To: Frank Ko[Frank.Ko@randwick.nsw.gov.au];
Cc: Bleasdale, Peter[peter.bleasdale@syd.com.au]; Barrington,
Lynne[lynne.barrington@syd.com.au];
Subject: TRIM: WALLACE WORTH BUILDING, UNI, KENSINGTON
Sent: Sun 8/15/2010 10:45:16 AM

BUILDING REQUIRES DEPARTMENT OF INFRASTRUCTURE APPROVAL

GFA LEVEL 7: 38 m² 1 Level 7 (Plant) 1:400

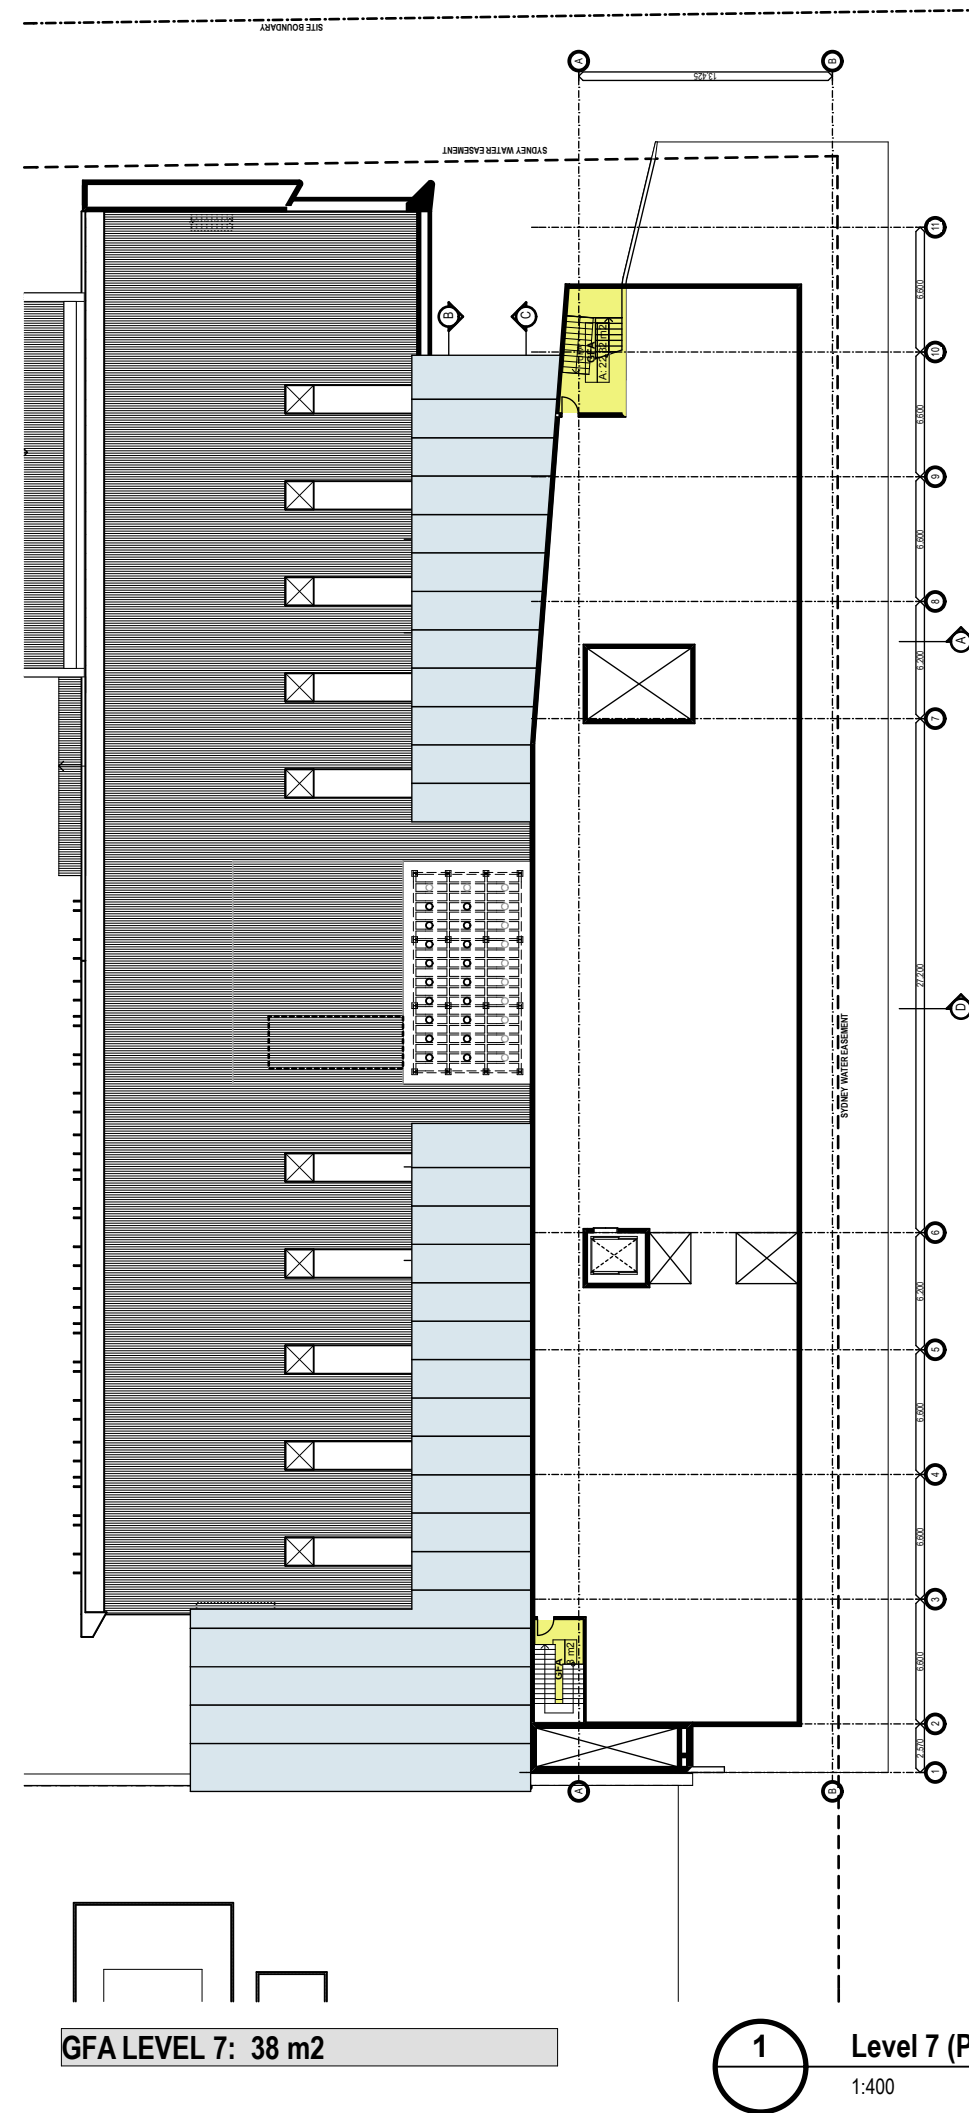
As the roofs Plant & Parapet at 90.7m AHD & the Exhaust Flues at 95.0m AHD

All penetrate the Airports OLS conical surface.

Figure 1: Plan view of Roof Level the proposed development including location of exhaust vent.

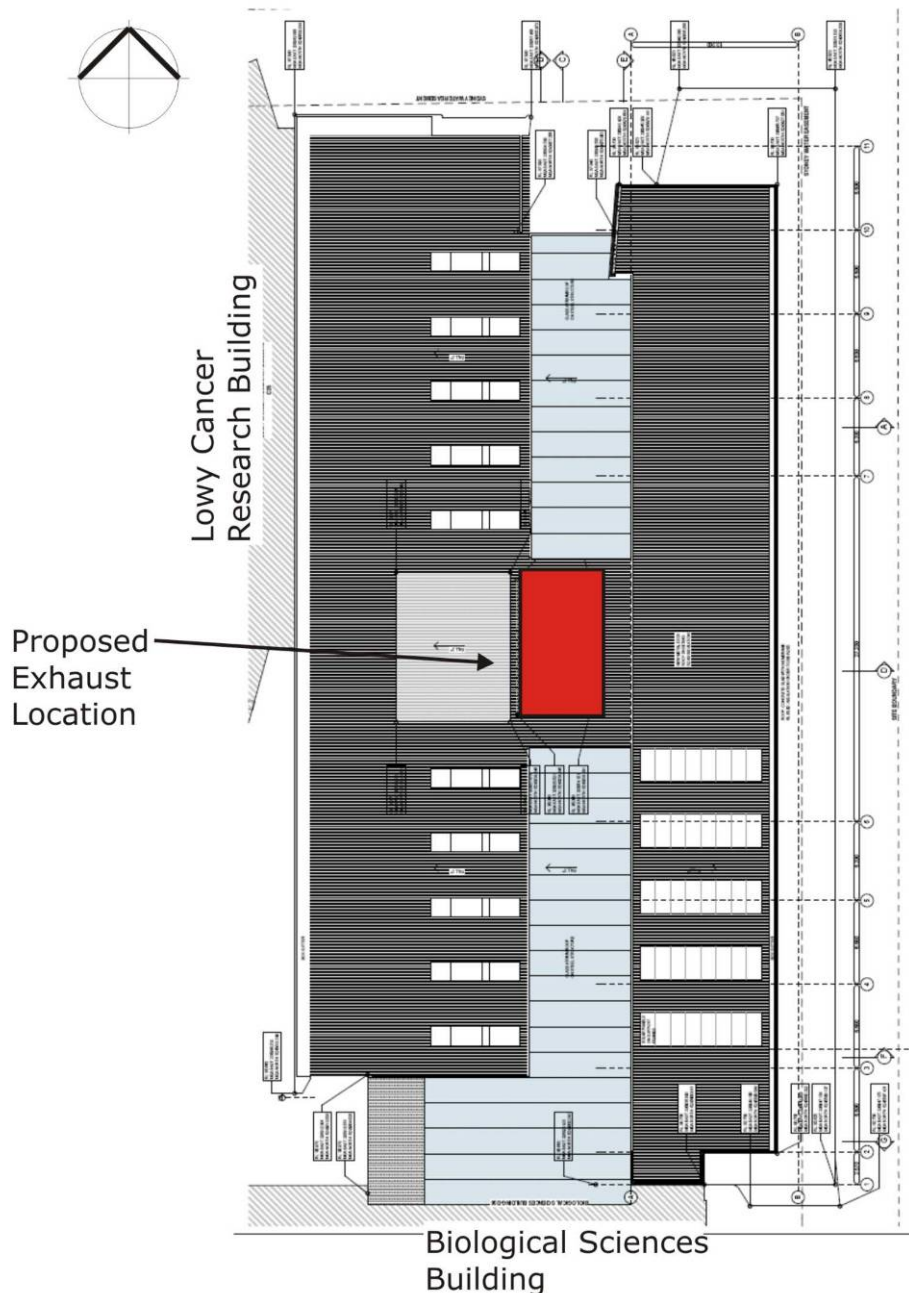
EXHAUST FLUES

Also shown on the Building plans is an area of Fume Exhaust Flues at 95.0m AHD for which The Airport will require advice of the exit speed of any exhaust fumes and if any plumes will result from the exhaust.

NOTE: If the exhaust exit speed is 4.3m/sec or greater or if any plume results from the exhaust a Civil Aviation Safety Authority (CASA) form called "Application for an Operational Assessment of a proposed Plume rise" will need to be completed by the applicant.

Please have applicant supply detail of the exhaust exit speed m/sec from the top of the exhaust flues and if any Plume will result from the flues. Sydney Airport will advise CASA and get back to you If there is any questions from CASA and if there is a need for the CASA form to be filled in and submitted for CASA's assessment.
